**85 HARRINGTON STREET
THE ROCKS**

ACCESS REVIEW

Morris Goding Accessibility Consulting

25th January 2016

For Information

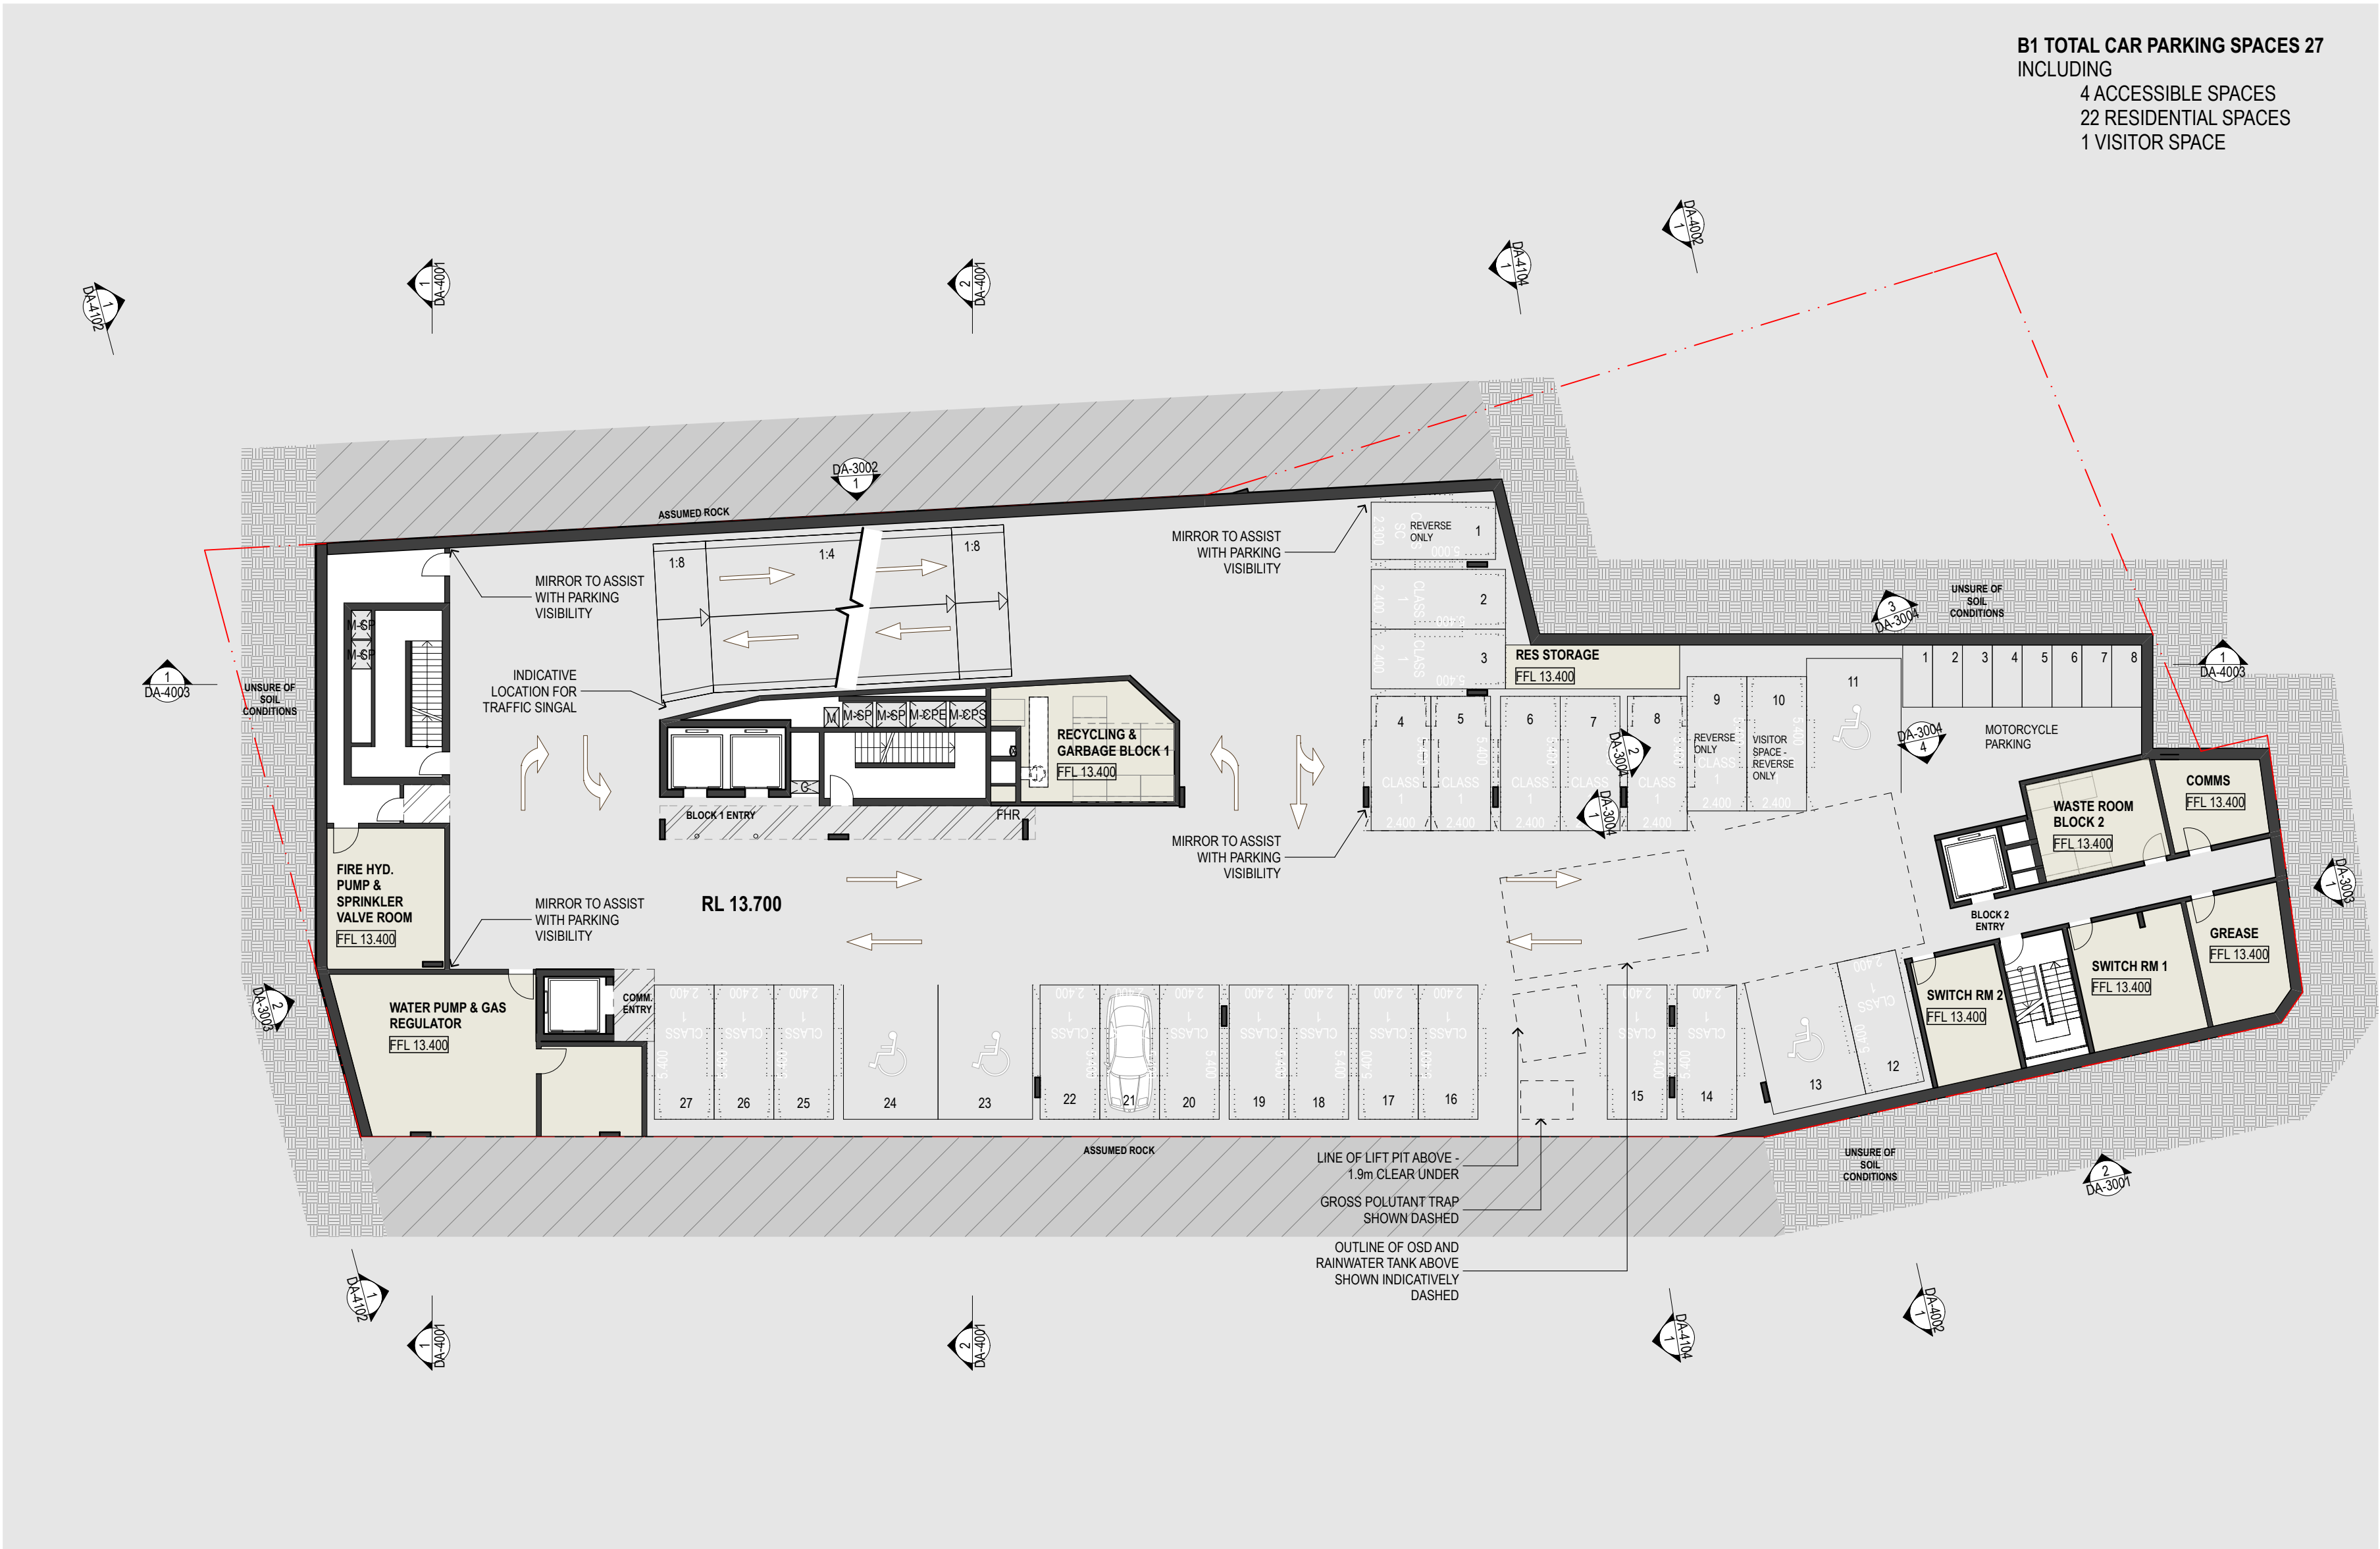
From the documentation provided there are 3 accessible car spaces provided within the Basement car parking levels, in the configuration of 3.8m x 5.4m compliant with AS4299. There are seven adaptable units provided. Review is required to provide a total of 7 accessible car spaces within the Basement car parking levels.

From the documentation provided it is unclear if retail and commercial car parking spaces are to be provided.

- (i) Provide 7 accessible car bays to be designated as adaptable car bays at the rate of 1 accessible car space/adaptable unit, compliant AS4299.
- (ii) Ensure the accessible car spaces for the adaptable units are 3.8m x 5.4m, compliant with AS4299 or alternatively 2.4m x 5.4m with a 2.4m shared zone adjacent, compliant with AS2890.6.
- (iii) Ensure accessible/adaptable car spaces are located in close proximity to relevant lift core (location of apartment).

SCALE	1:200 @ A2	PROJECT CODE
DATE	11/09/2015	GA85H
SHEET NO.	DA-2000	REVISION
		I

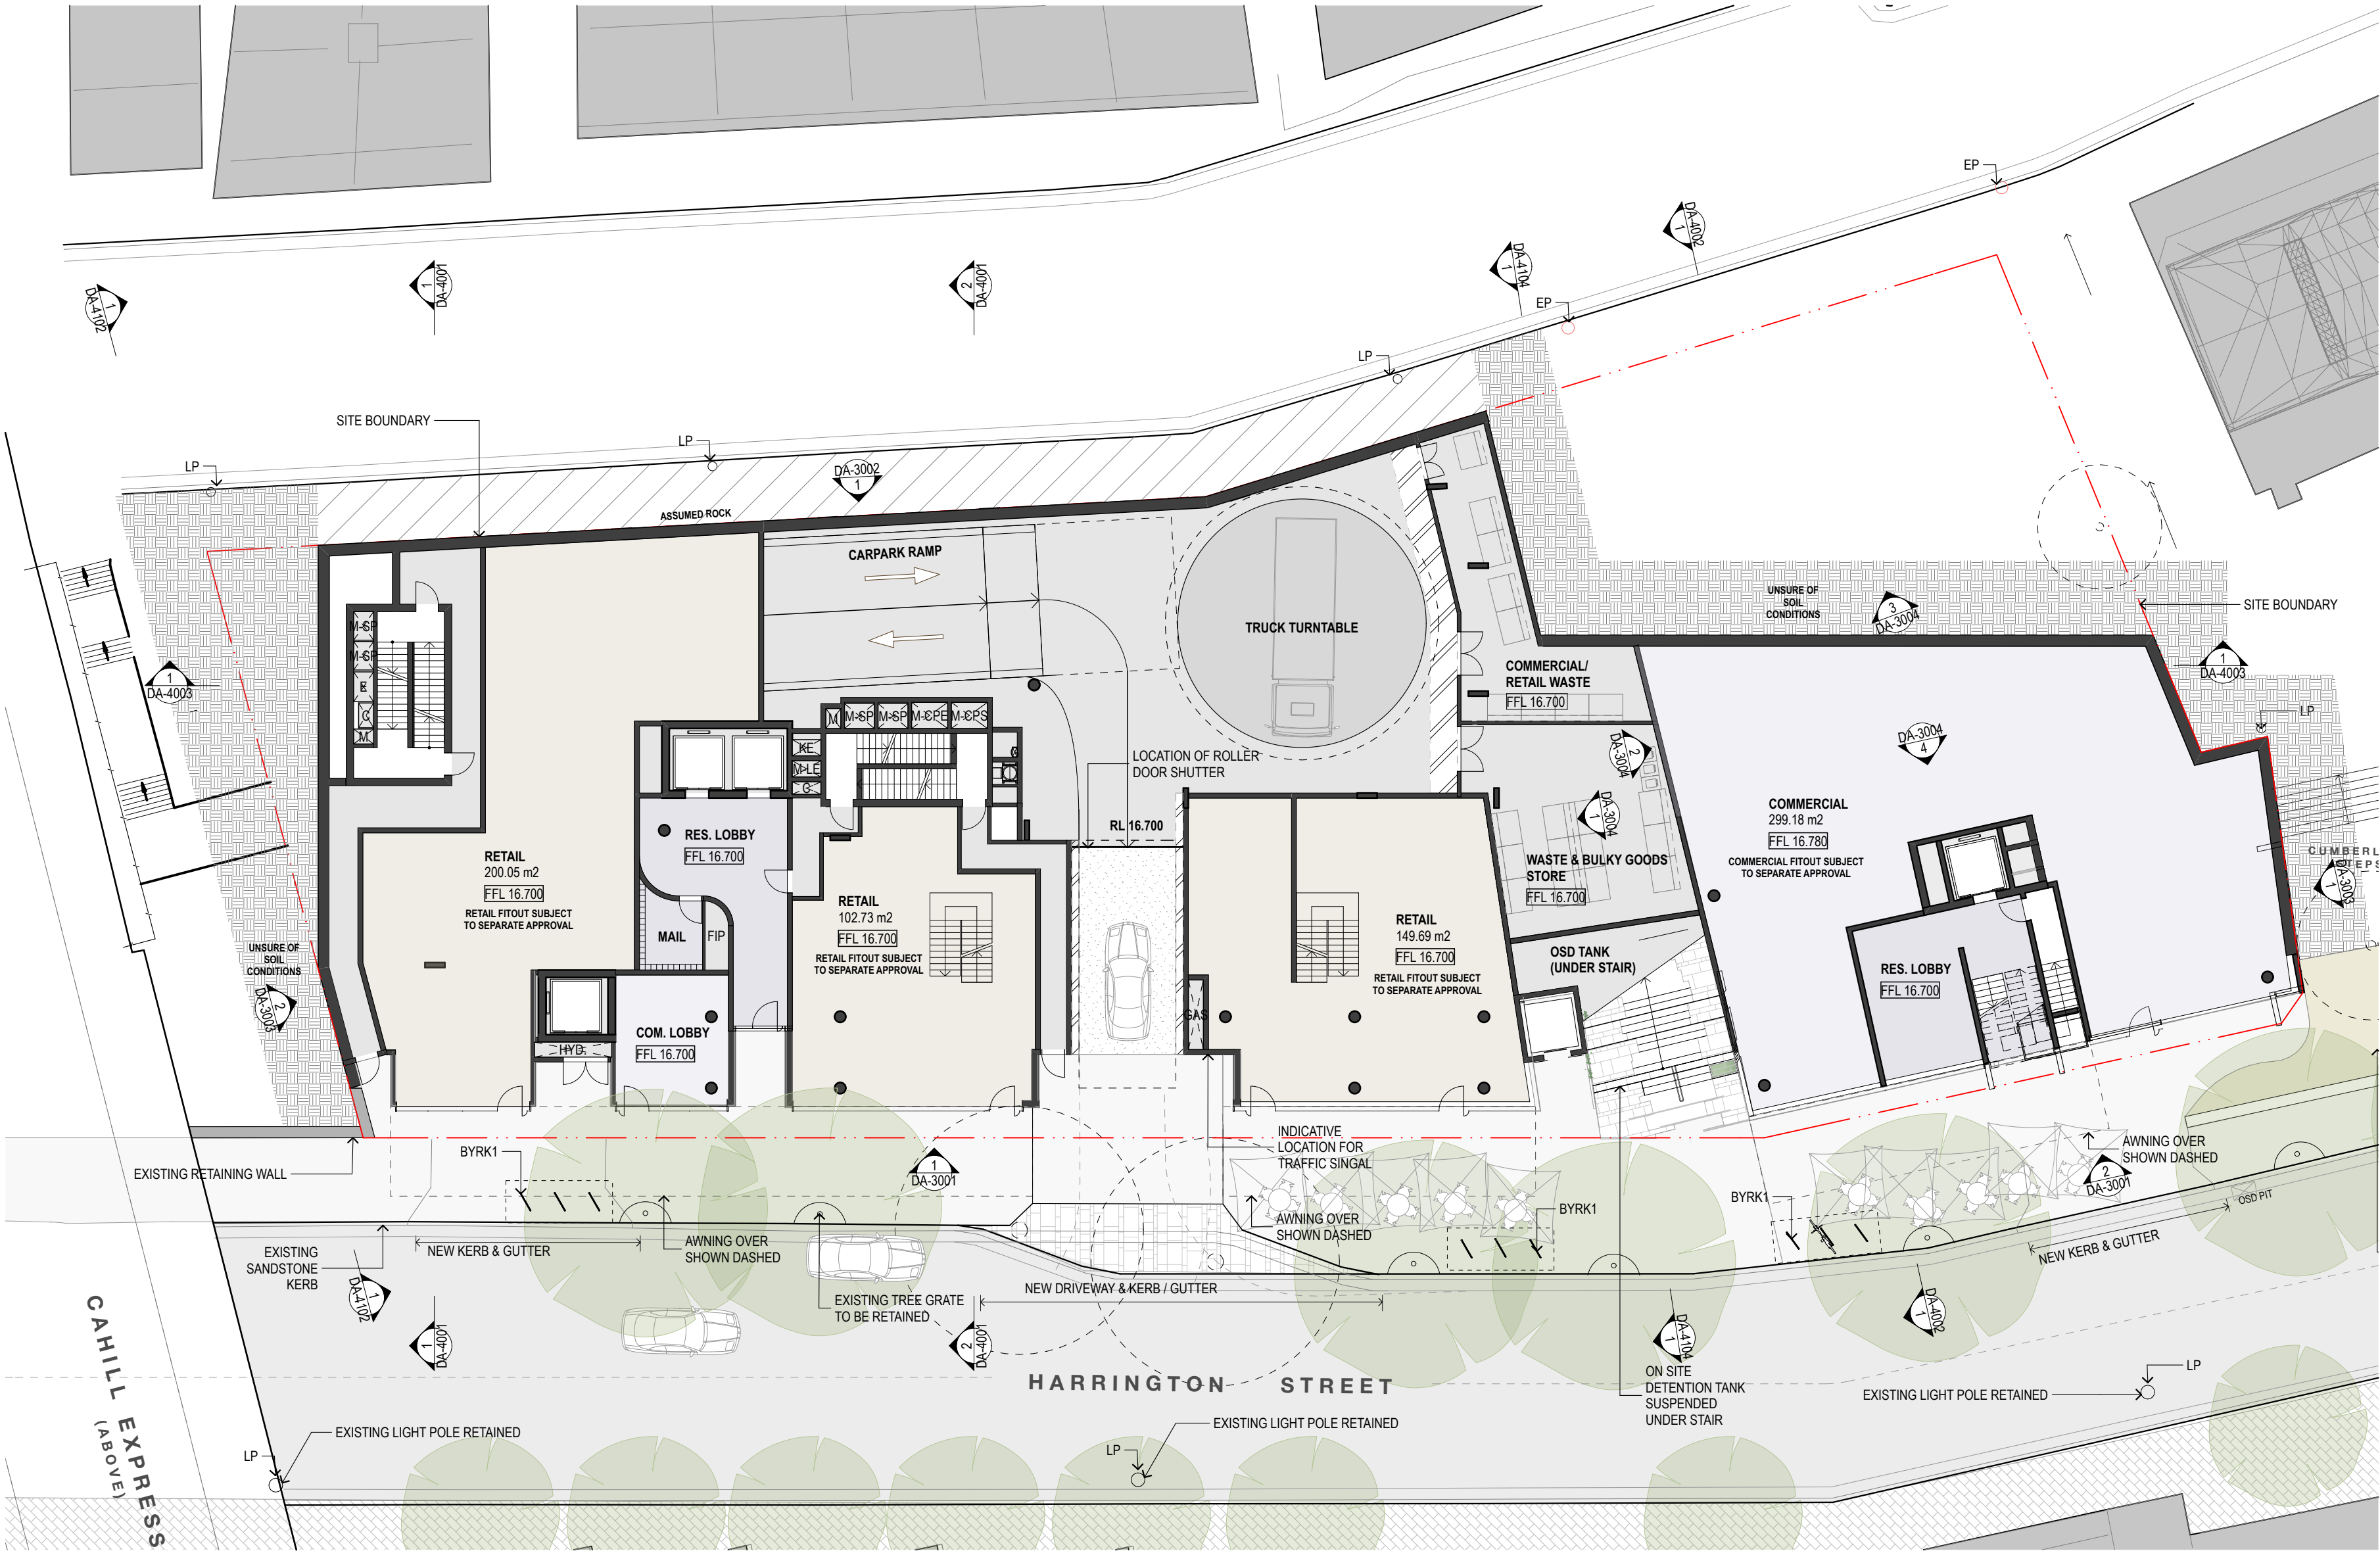
There are two main entries located off the pedestrian footpath (Ground Floor Level) of Harrington Street to the residential lobbies of Block 1 and Block 2. From the information provided the entrances achieve compliant opening widths and circulation inside and outside of the proposed hinged/pivot doors compliant with AS1428.1:2009.

It is unclear where the residential mailboxes are located for residential Block 2; review is required to meet AS4299 requirements.

- (i) Ensure residential mailboxes are provided for Block 2; with a 1550mm turning area outside of the letterboxes, preferably under cover and on the path of travel to the entry, compliant with AS4299.
